17/12/2019

**New Public School, Estella Road, Wagga Wagga (SSD-9494)
Response to Submissions**

Attachment 1

WAGGA WAGGA PS
ESTELLA ROAD, ESTELLA, NSW, 2678
NEW HIGH QUALITY CLASSROOMS PACKAGE 2
DRAWING NAME
FENCING PLAN & DETAILS

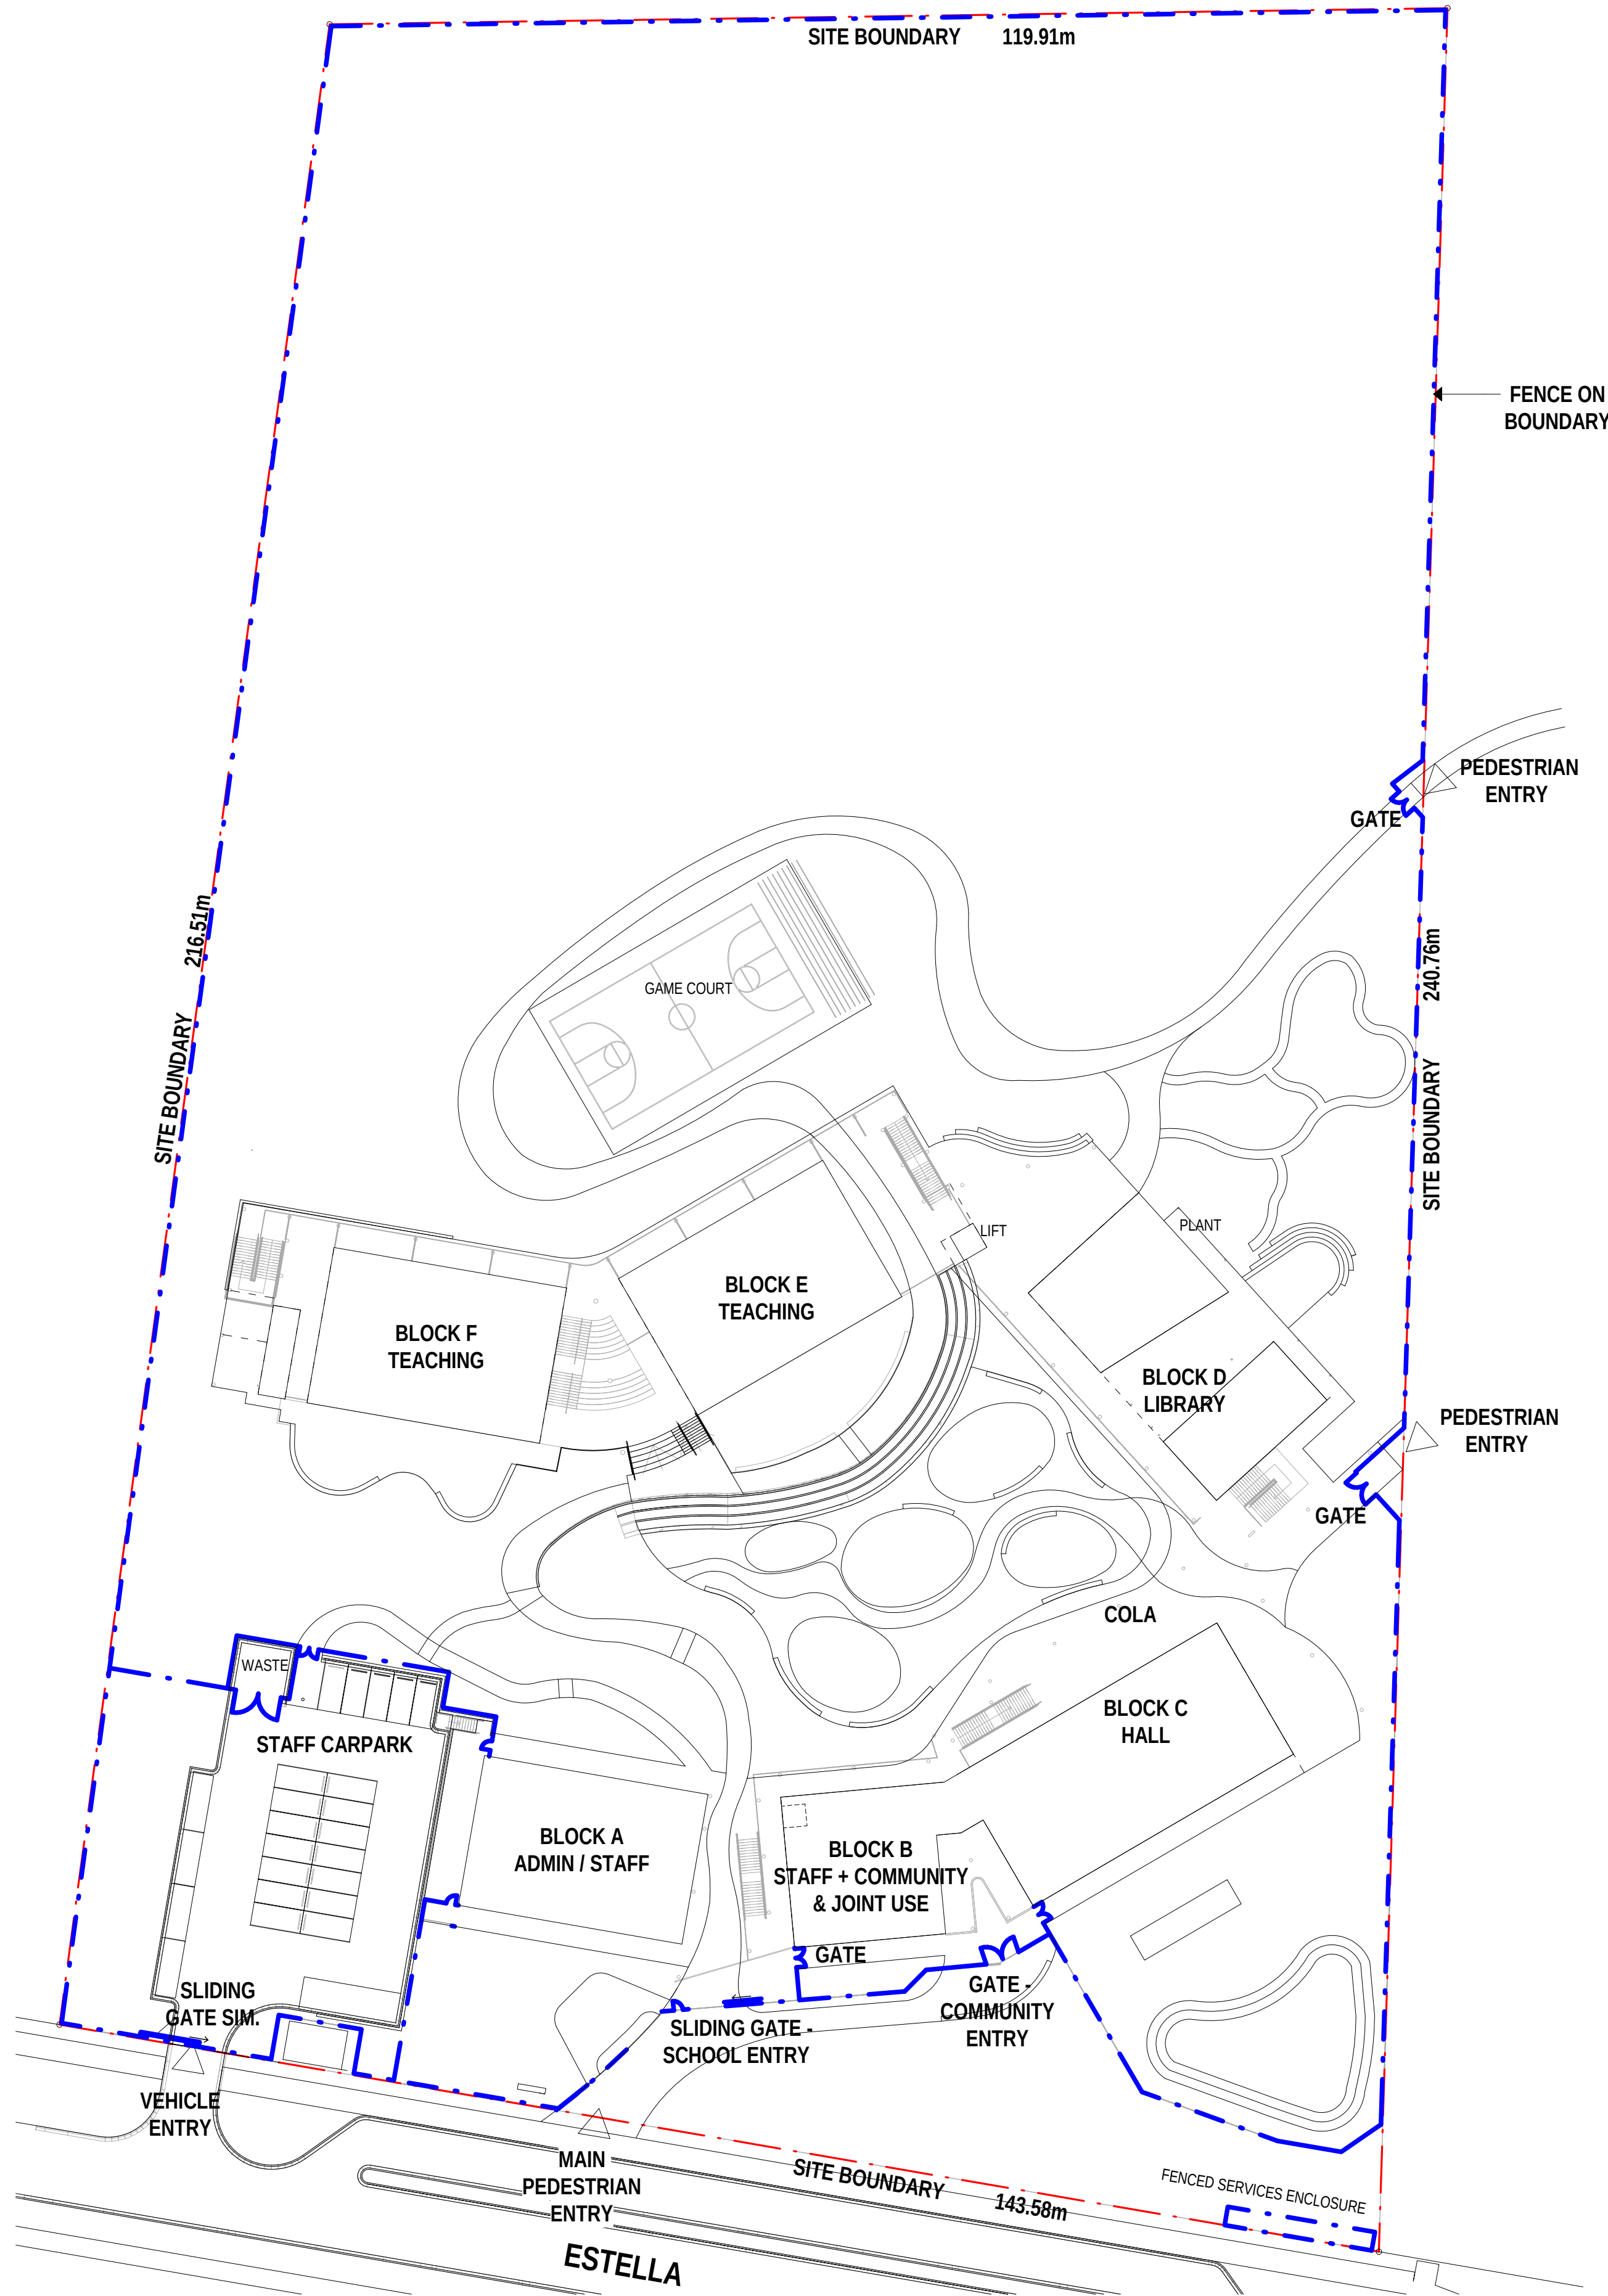
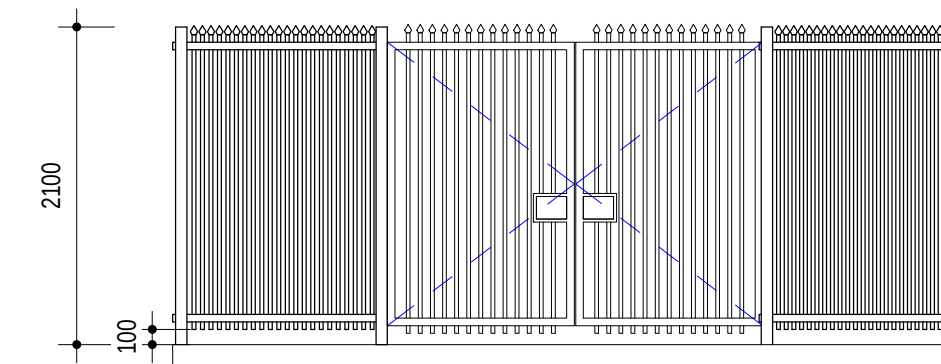
- Provide further details of the proposed fencing of the site, including the location, height and type of fencing, and demonstrate that this is suitable to the open rural character of the location.

WAGGA WAGGA PS
ESTELLA ROAD, ESTELLA, NSW, 2678
NEW HIGH QUALITY CLASSROOMS PACKAGE 2
COMPOSITE PLAN - LEVEL 00

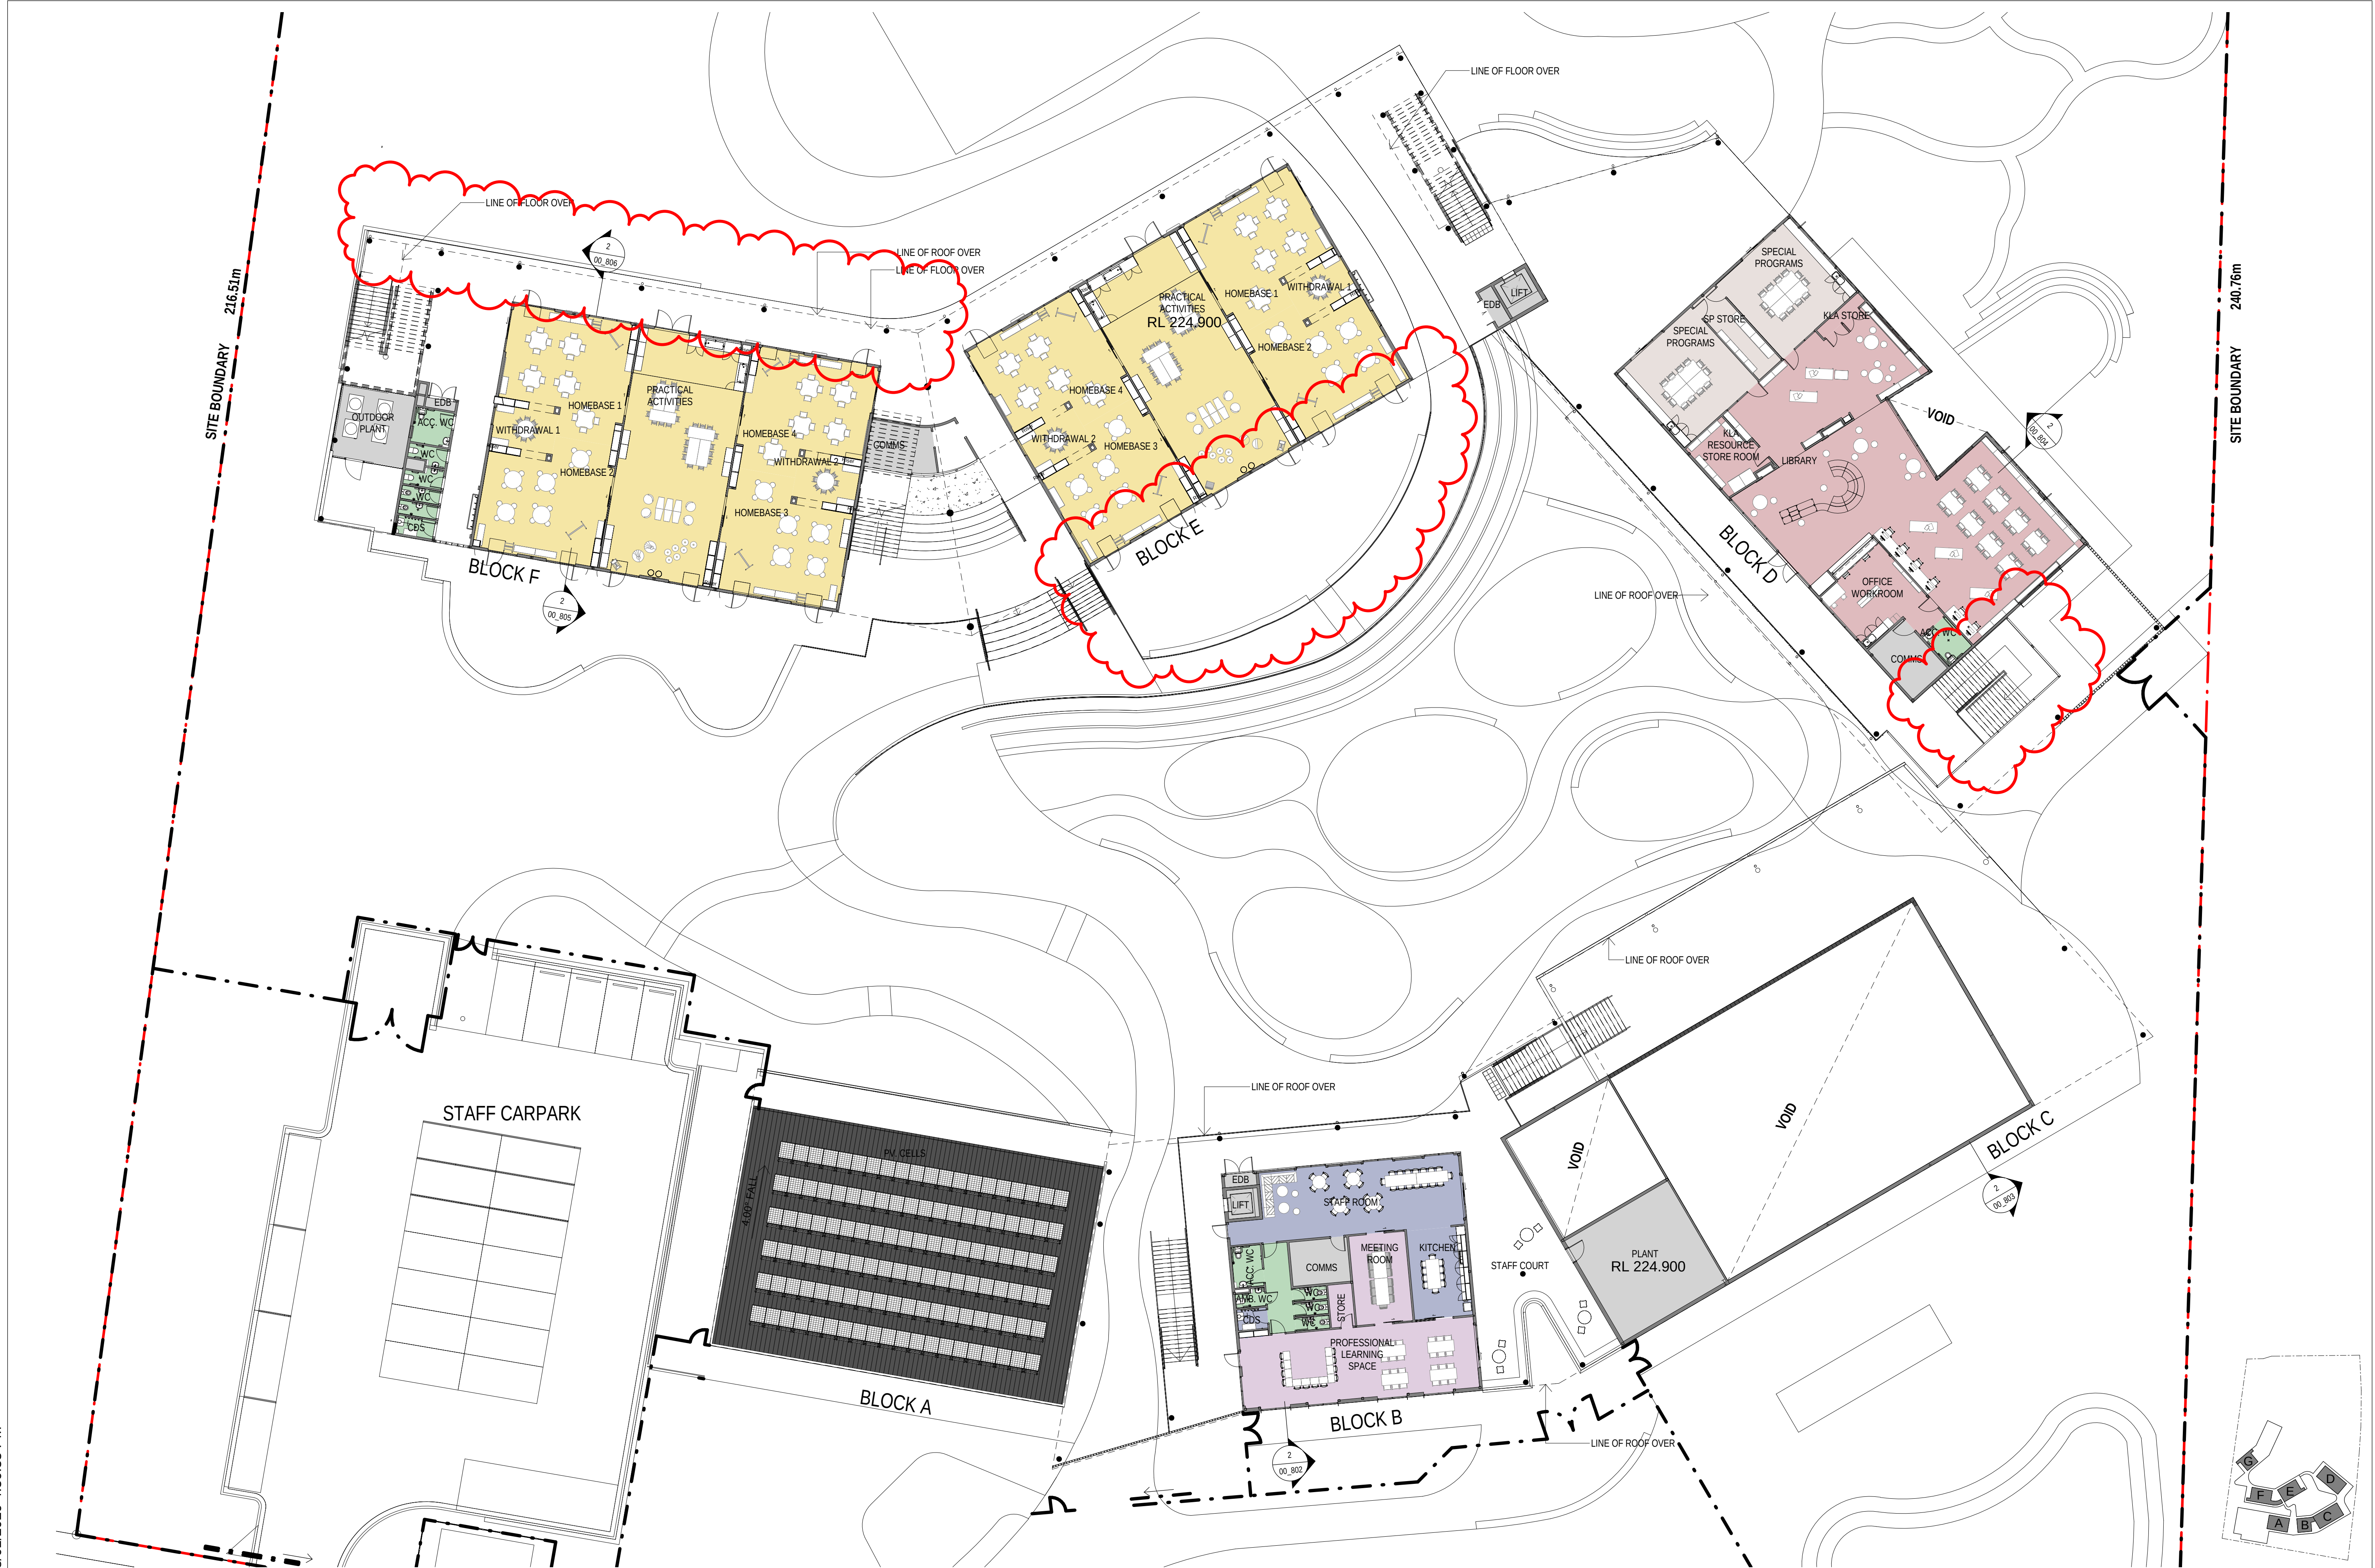
- Provide information to demonstrate that sufficient parking would be provided on site (notwithstanding the provisions of the Wagga Wagga Development Control Plan 2010) to cater for demand for staff at the school given:

- the context of the site and consequent likelihood of high reliance on car-based travel; and
 - the need to avoid staff parking on Estella Road, particularly given its design as a rural type road and undesirability of parking on the road and consequent impacts on road safety.
